CITY OF ALBUQUERQUE

**Re: Harley Davidson Modesto/Eagle Rock Drainage Report and Grading Plan
Engineer's Stamp date report 2-27-12, Grading Plan 2-12-12 (C18/D080)**

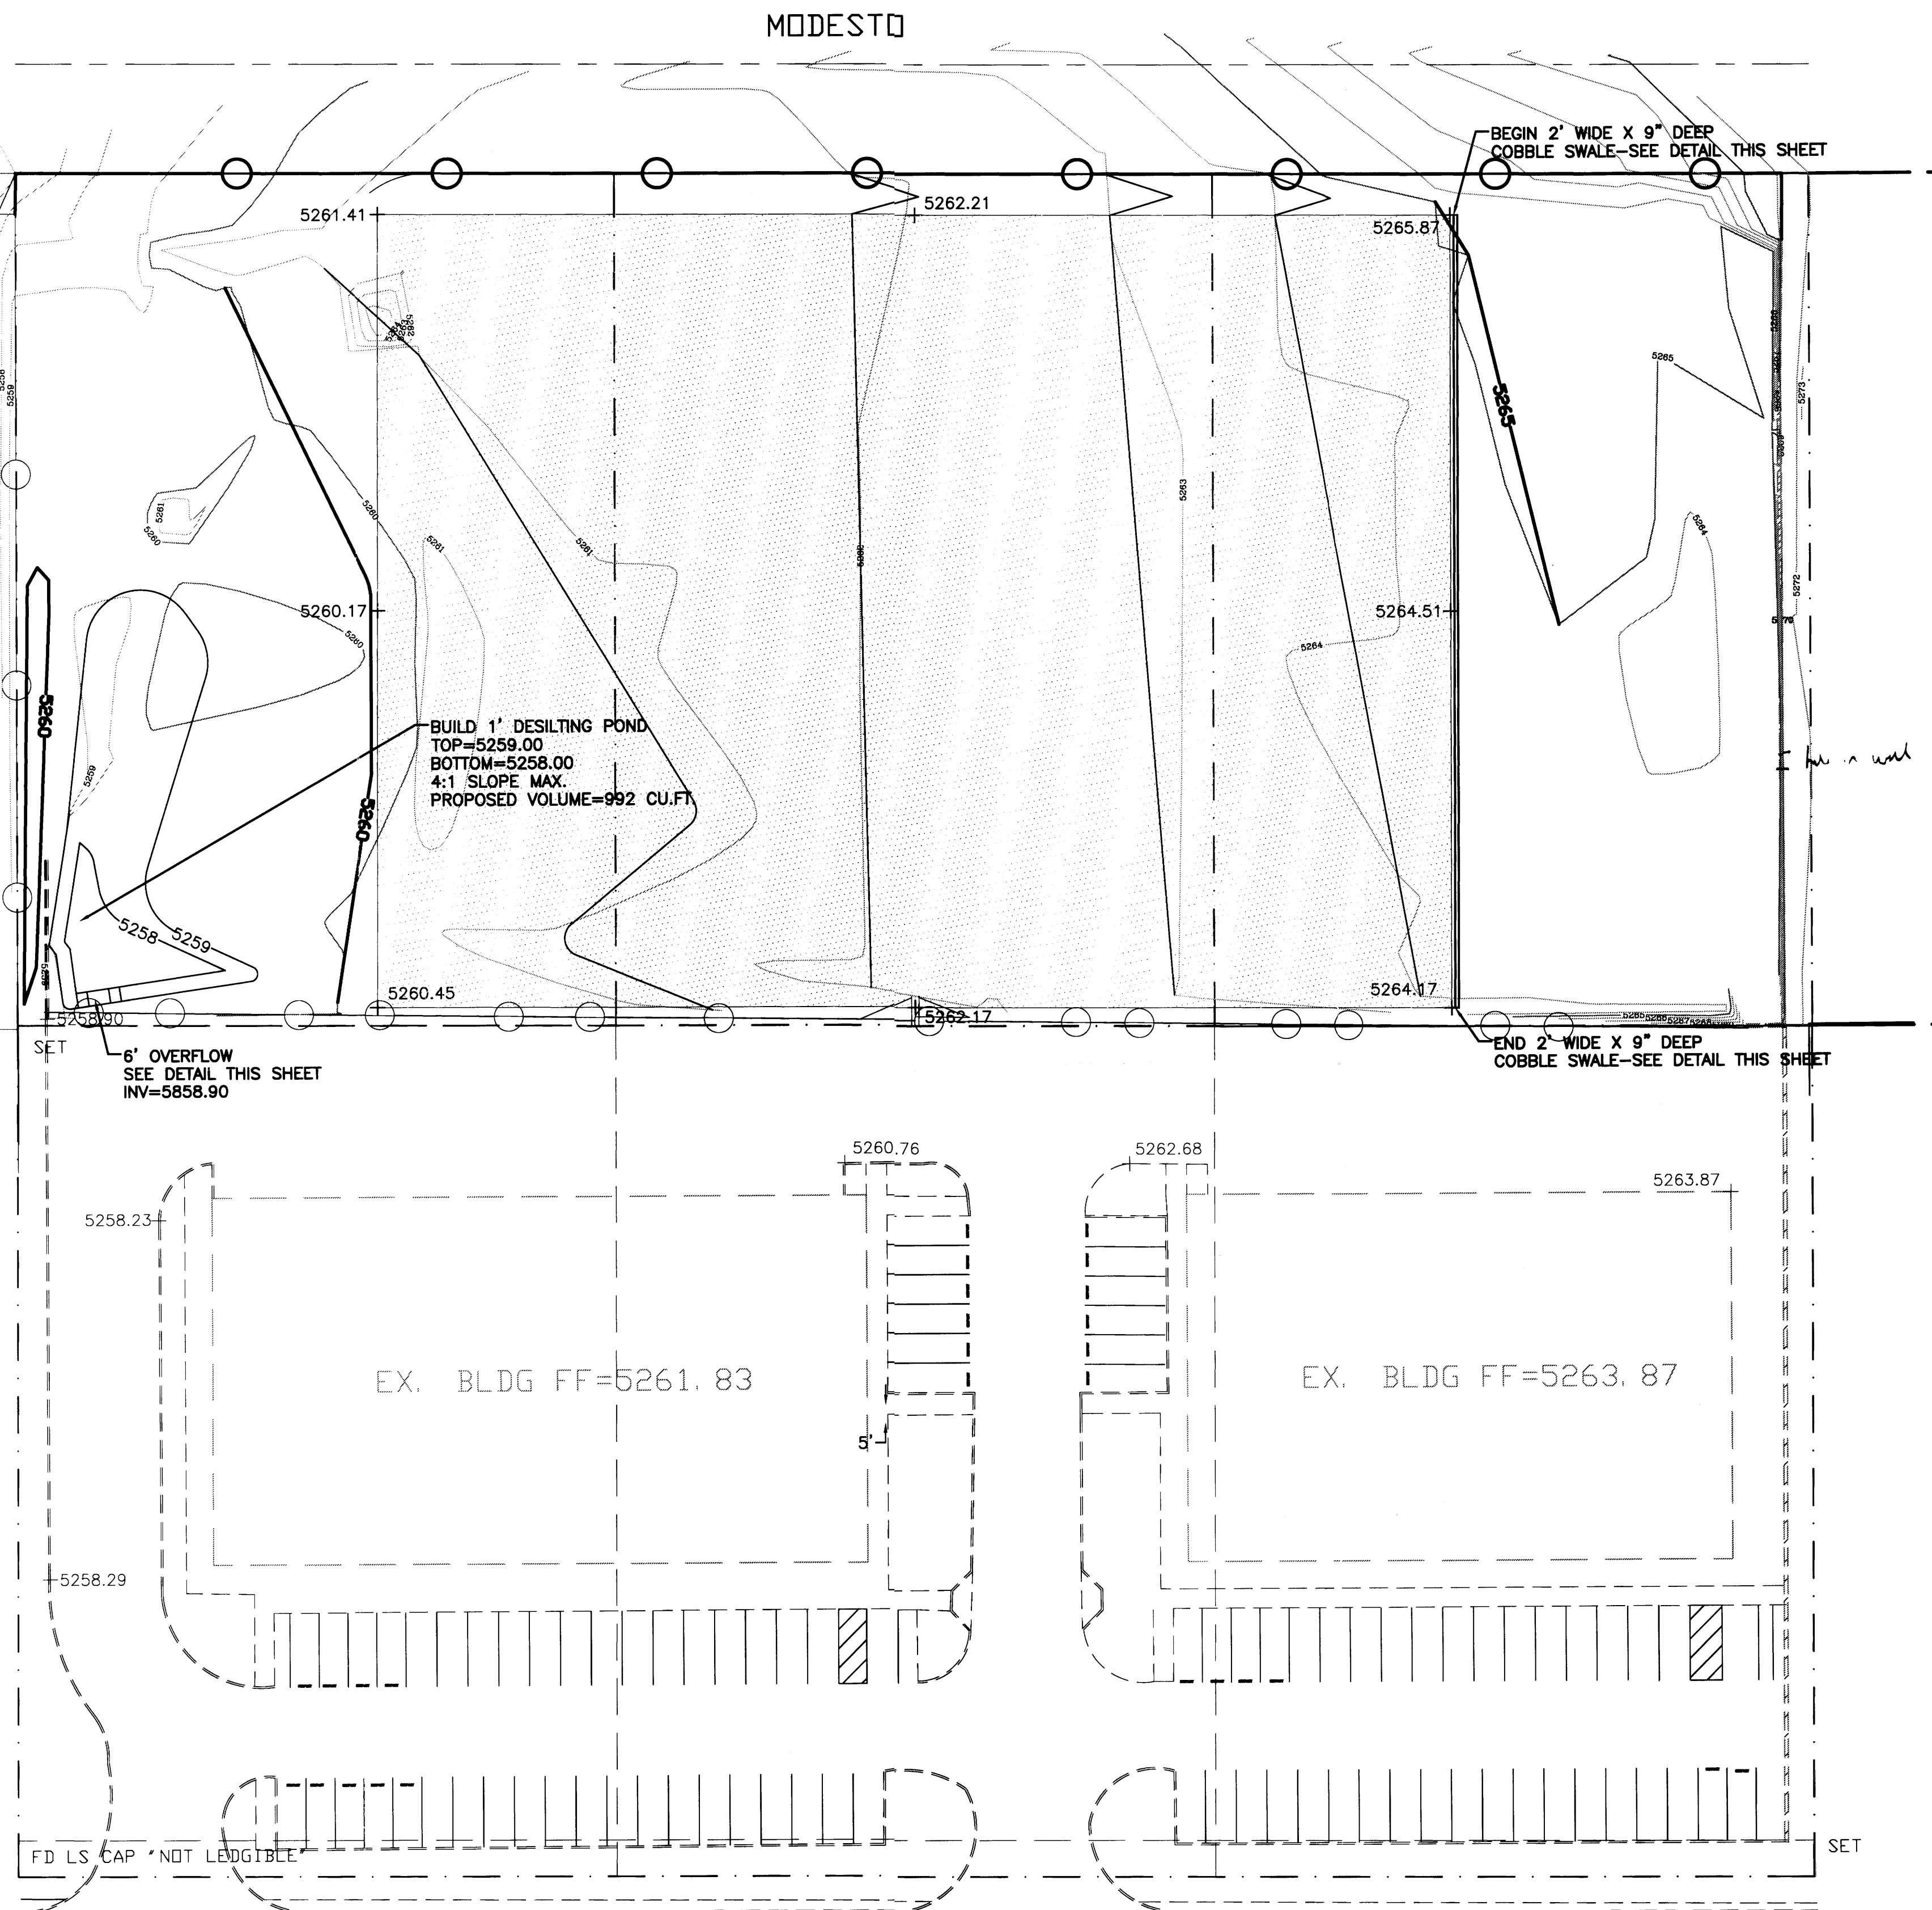
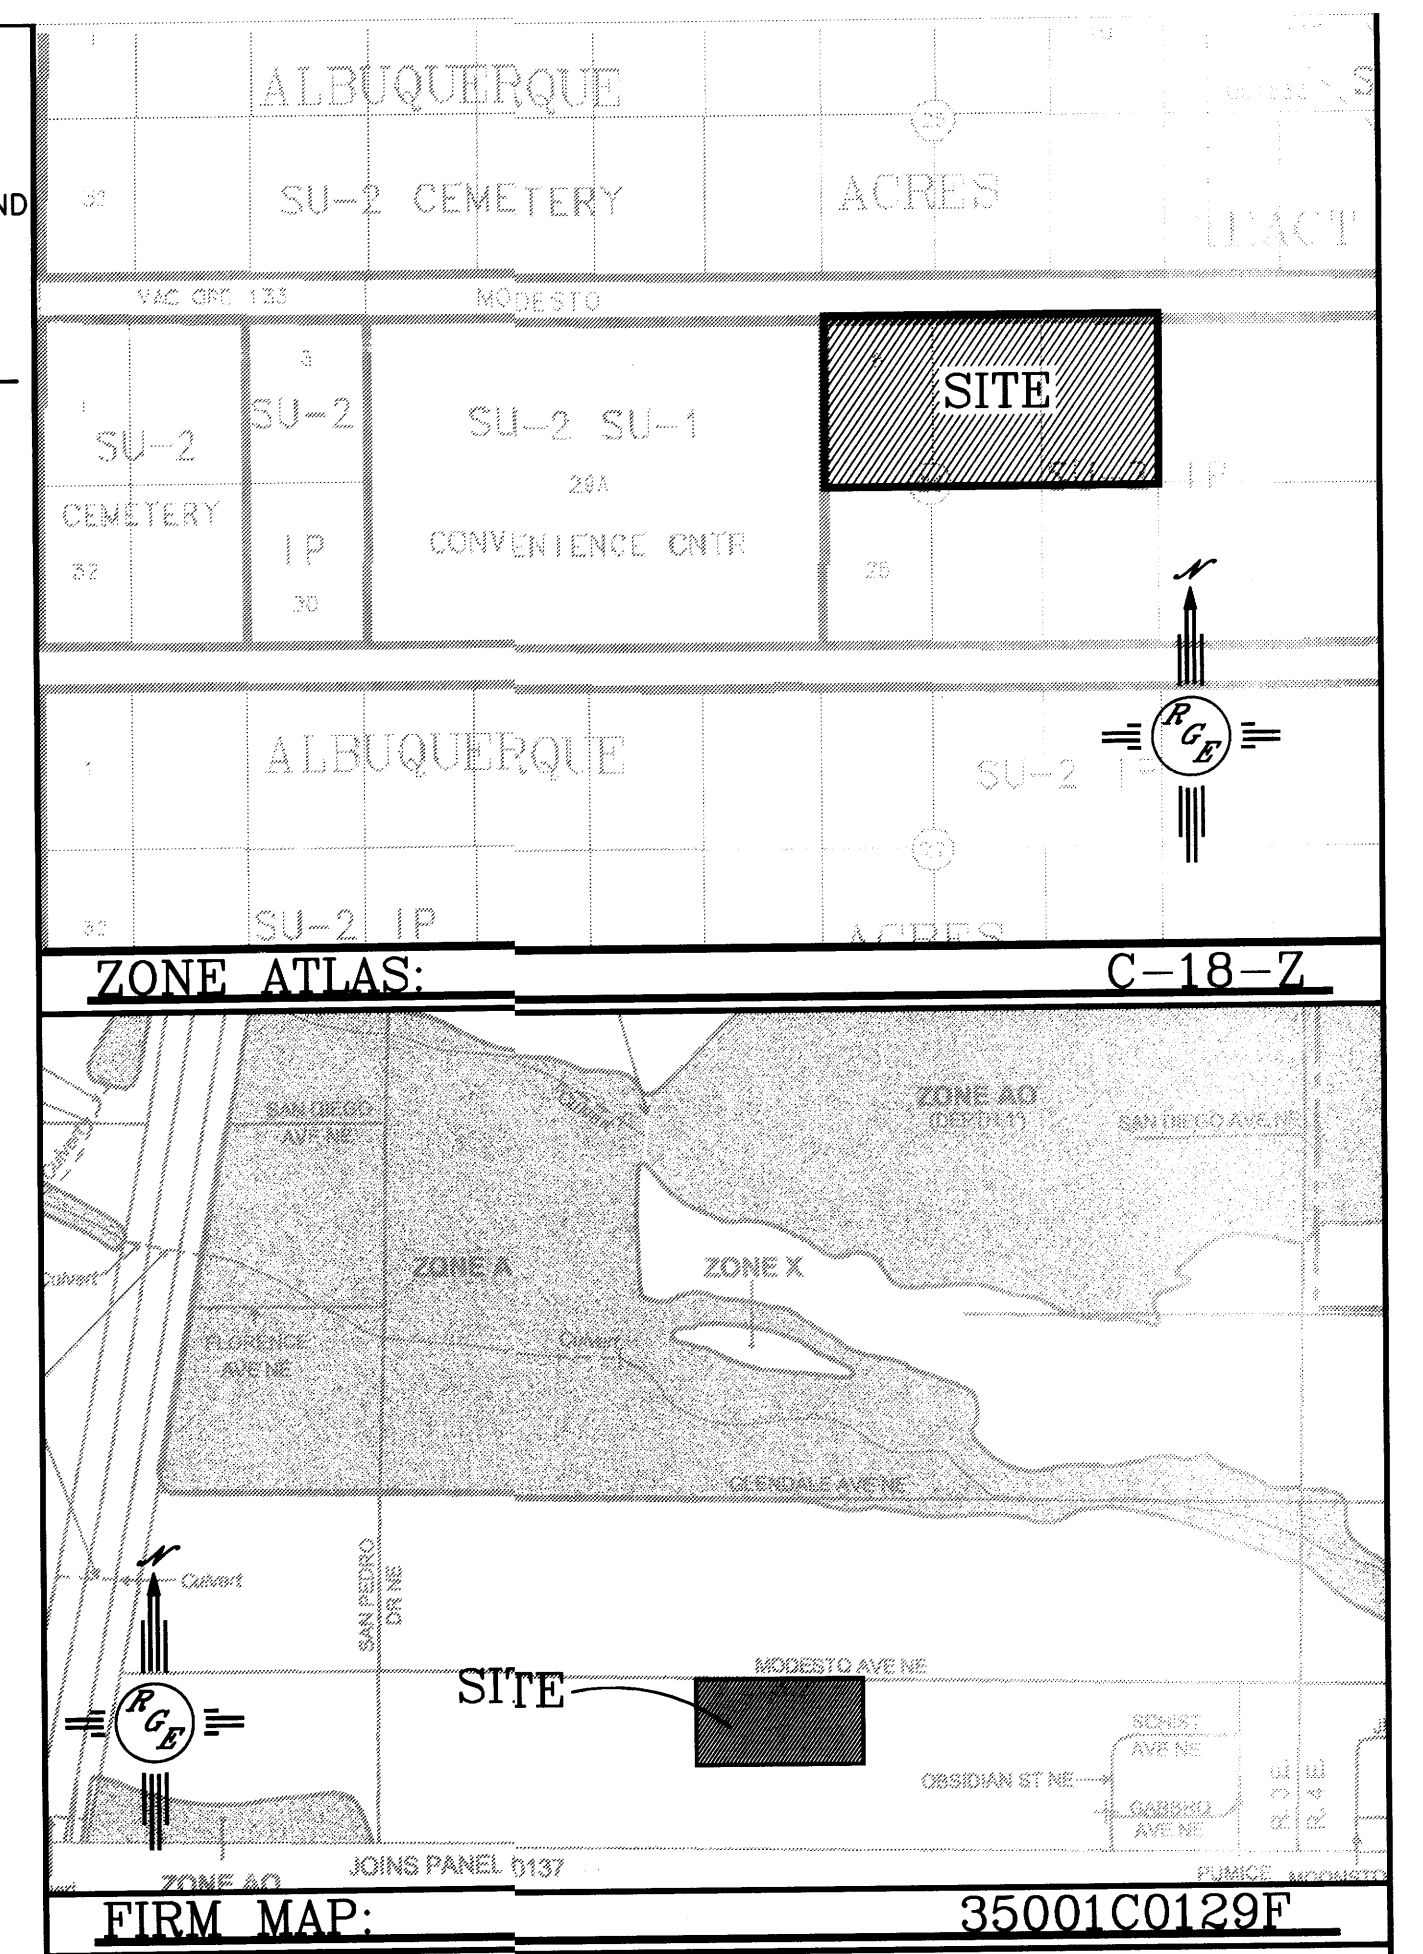
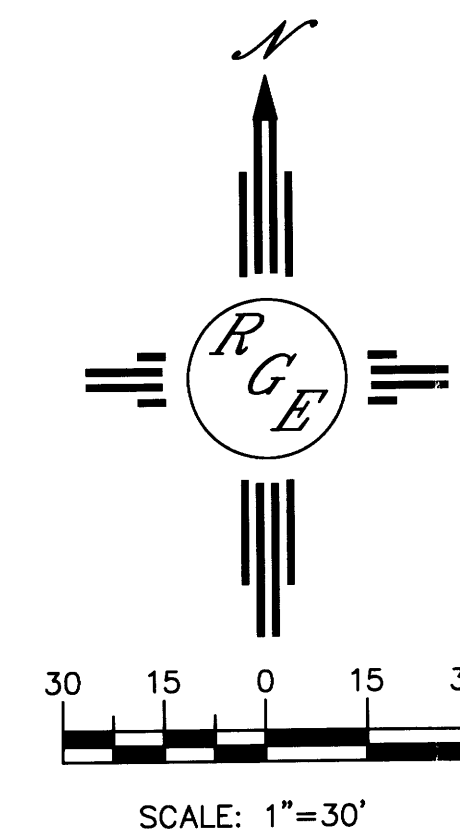
- The report states the site is not affected by offsite flows. Previous reports mentioned this site accepting the offsite flows from the two lots to the east. The previous grading plan had proposed cuts in the east retaining wall to accept these flows. For some reason they were not built.
